From: Iain Osenton
Sent: 05 July 2022 11:54
To: Katherine Daniels
Cc: dcregistration ; Planning
Subject: 22/01772/PIP - CDC Arboriculture

With this in mind, as there is a TPO on the site, along with several trees bordering properties to the south, I'd suggest an arboricultural report including impact assessment and method statement to BS5837:2012 should be submitted for review in order to ensure the retention of key trees within the site.

Block Plan

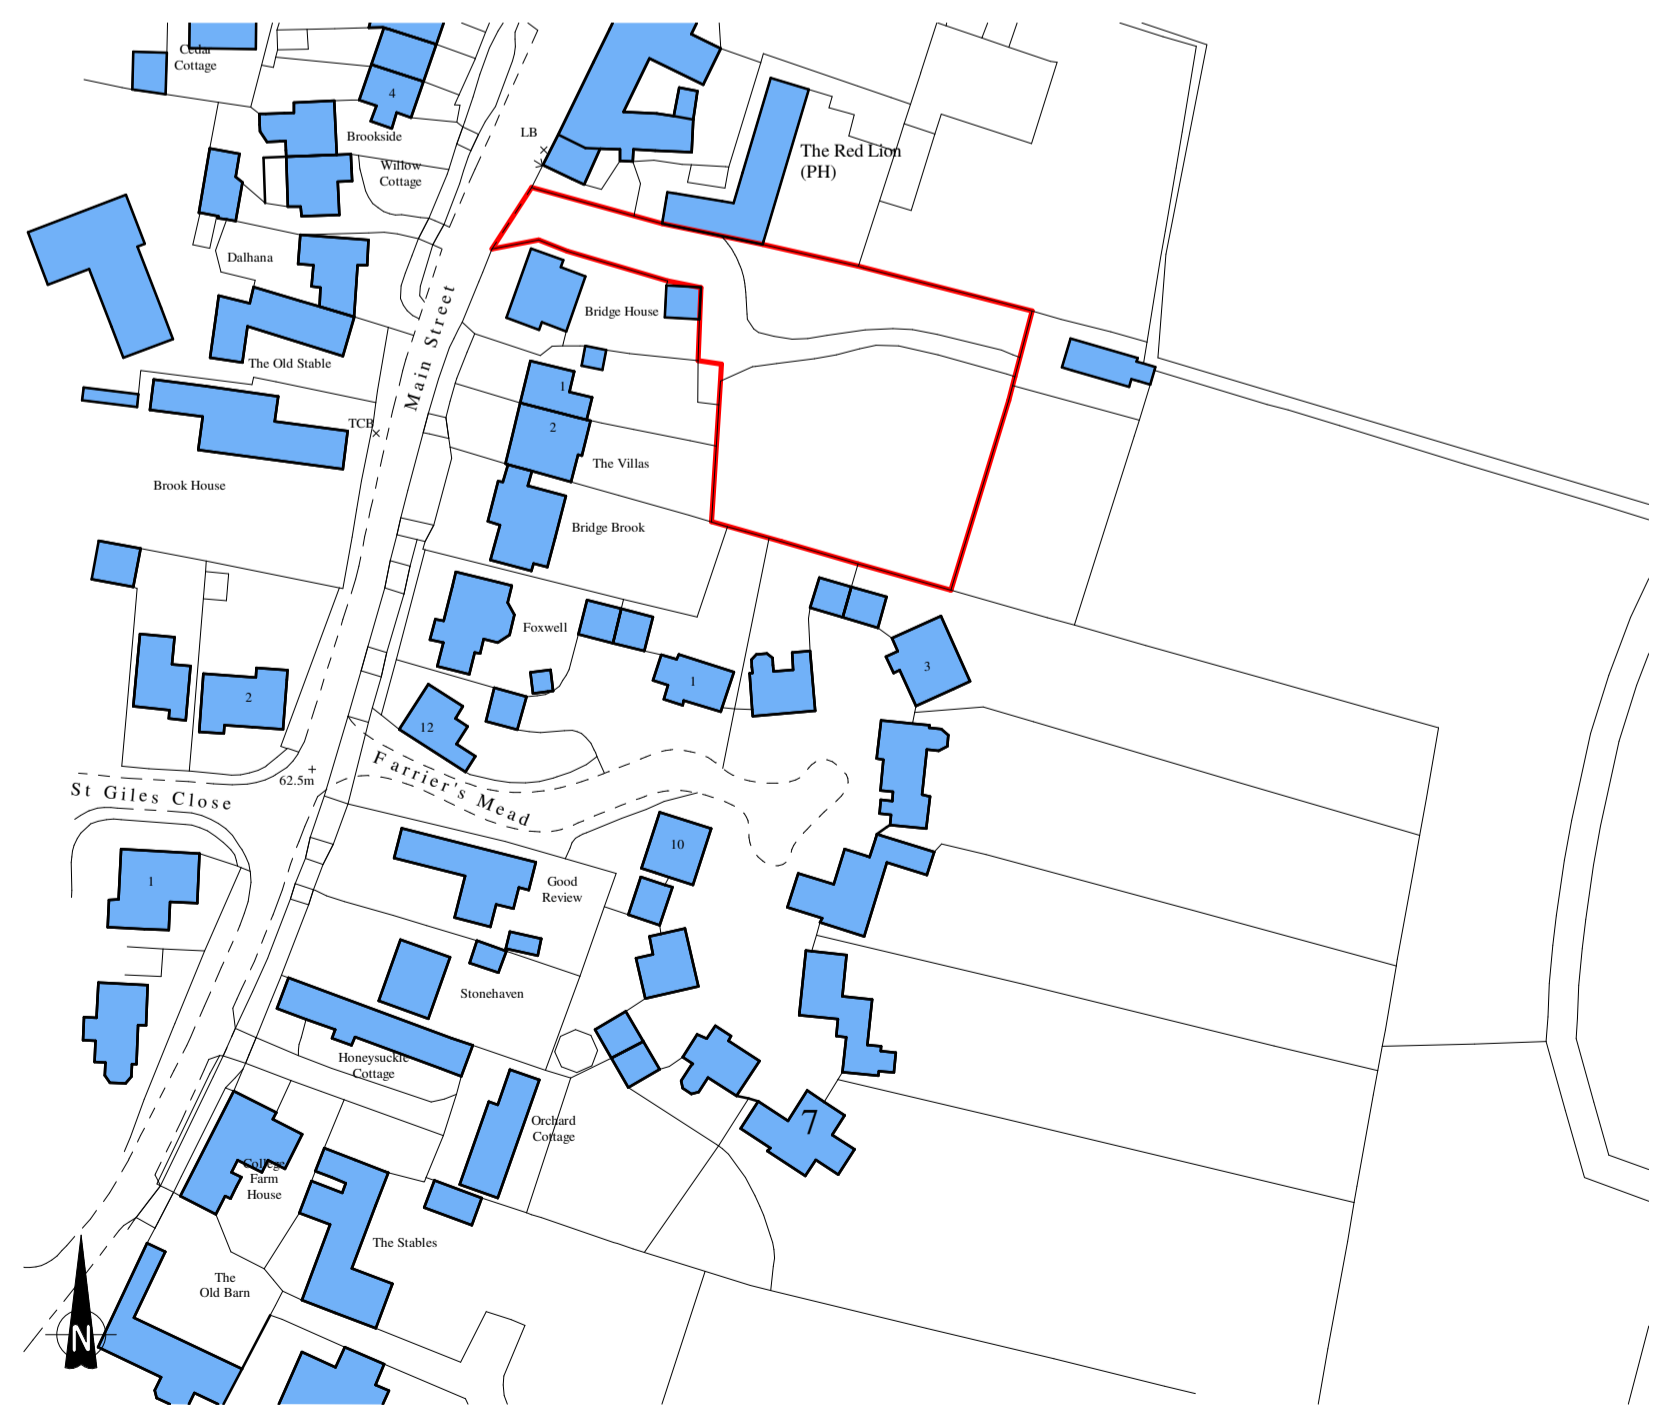
I don't believe arboriculture was consulted on the above application however, I'm involved in the site as the site owner has been requesting the TPO covering a walnut to the south border of the site be revoked.
